From: Martyn White <Martyn.White@arun.gov.uk>
Sent: 21 December 2021 17:16
To: Planning.Responses <Planning.Responses@arun.gov.uk>
Subject: LU/396/21/DOC

The Farm 39 East Street Littlehampton BN17 6AU

Approval of details reserved by condition imposed under LU/135/21/L relating to conditions 3-full details of new external doors & windows, including sections & treatment along with details of new porches; 4-details of proposed removal of existing traditional windows; 5-details of all new internal joinery such as doors & skirting boards; 6- details of the proposed location, heights, materials & finishes of boundary treatments

Drawing Name
Elevations - Proposed Discharge of Conditions

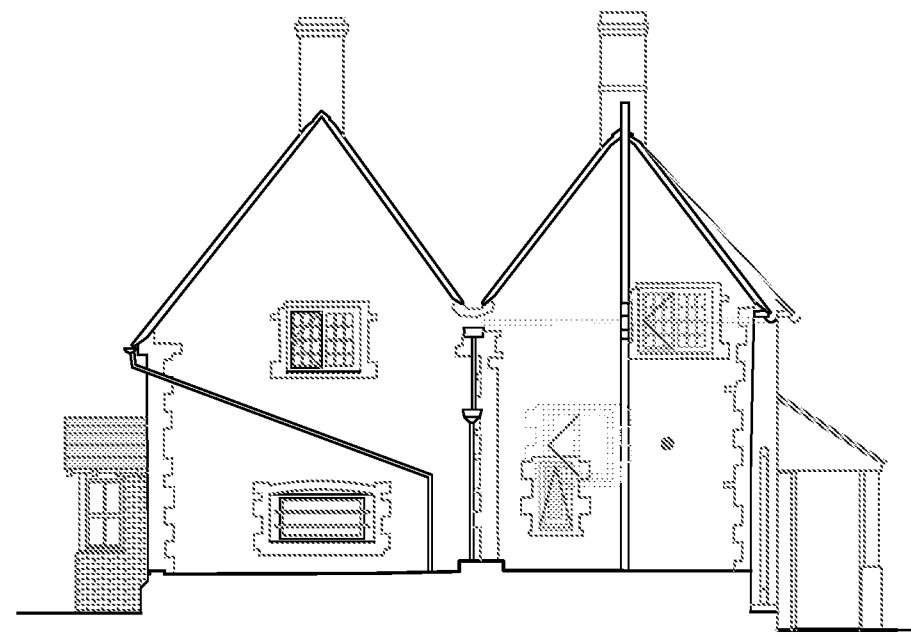
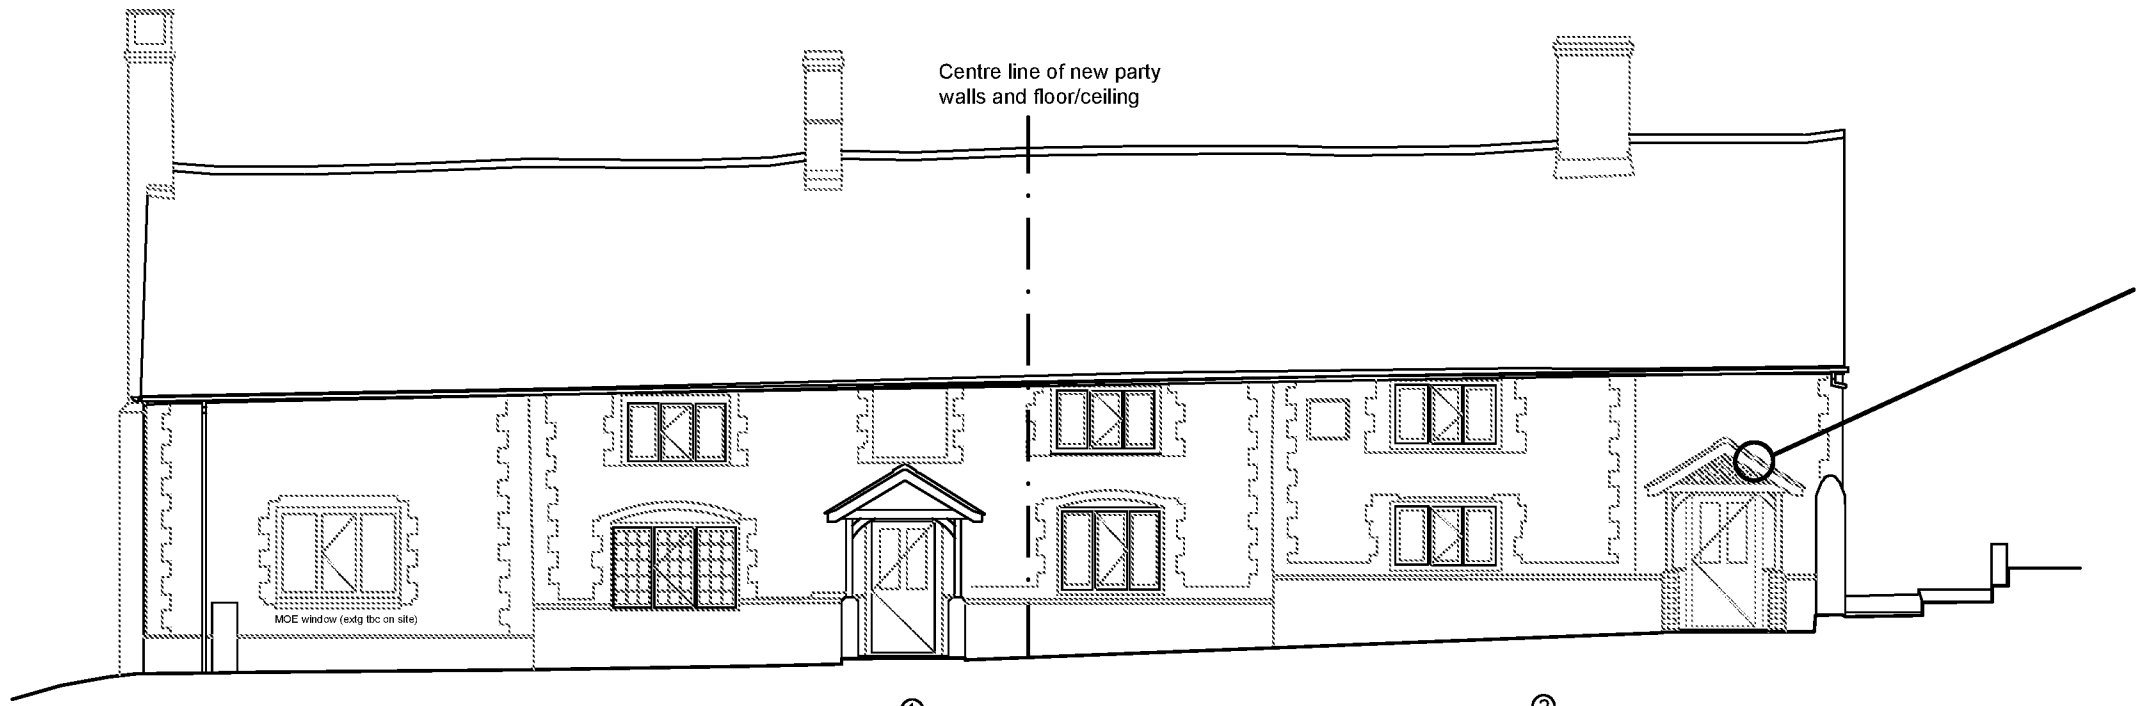
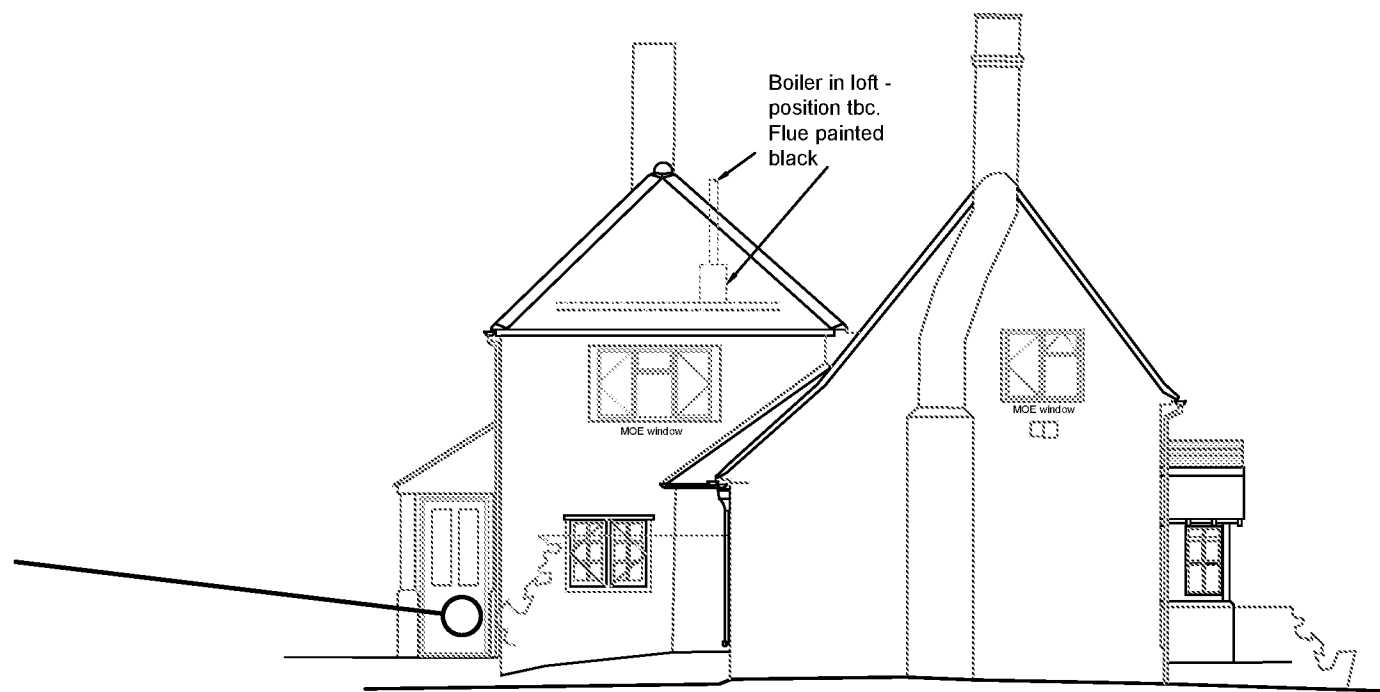
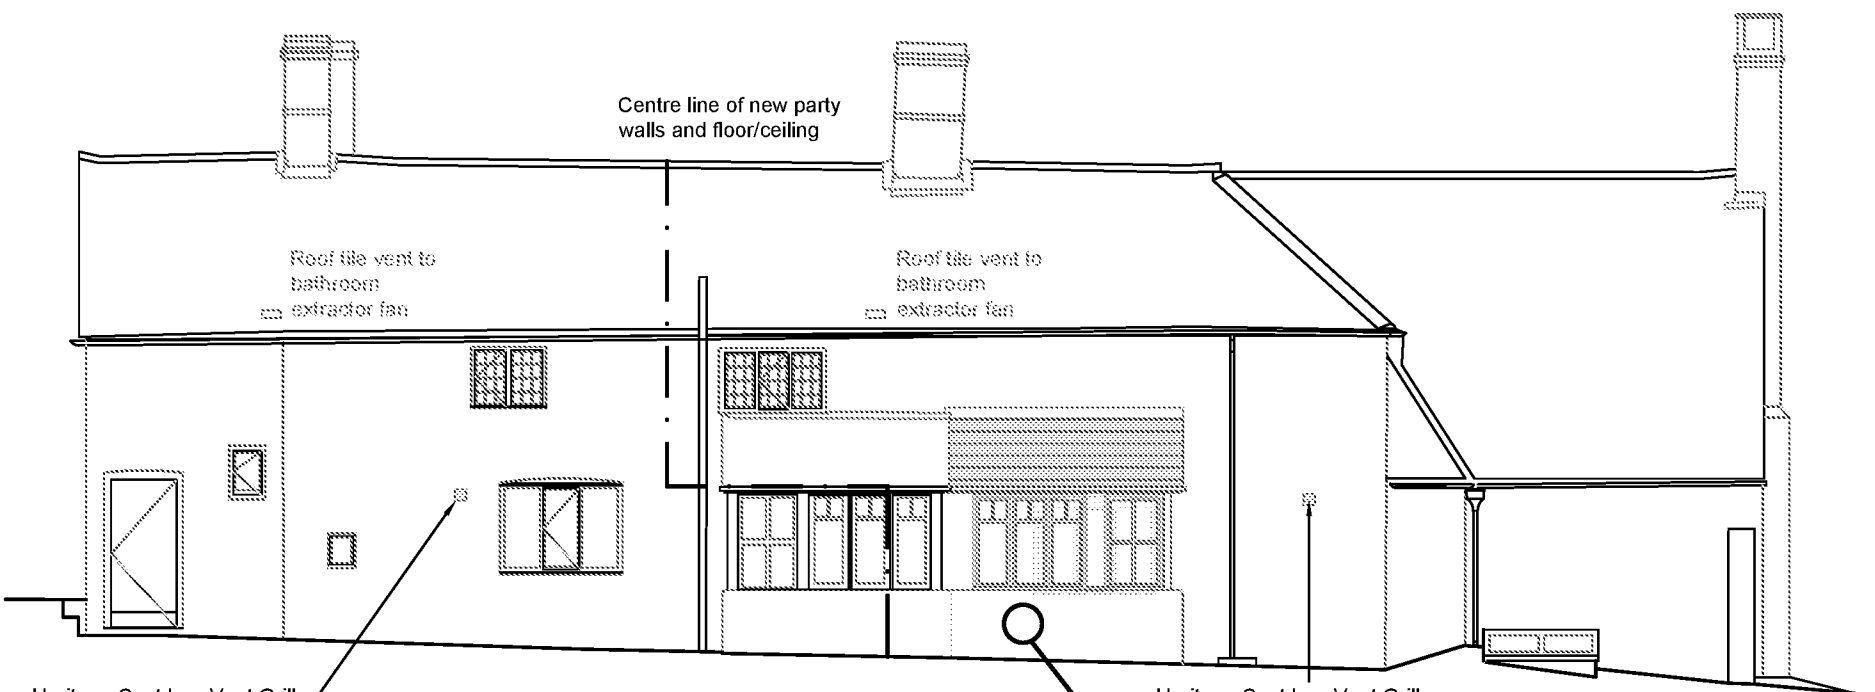
Conditions 3 & 4 – I am unable to locate the section of the windows in unit 2: GF W6 and FF W16. The statement indicates that FF W16 will match the existing first floor window on the same elevation. However, this is not fully clear from the drawing of the front elevation only.

Further, I am unable to see an information regarding the window for the porch W10 or the replacement window/door identified as ED6.

Furthermore, it is not clear if any works are planned to take place to W1. This needs to be clarified.
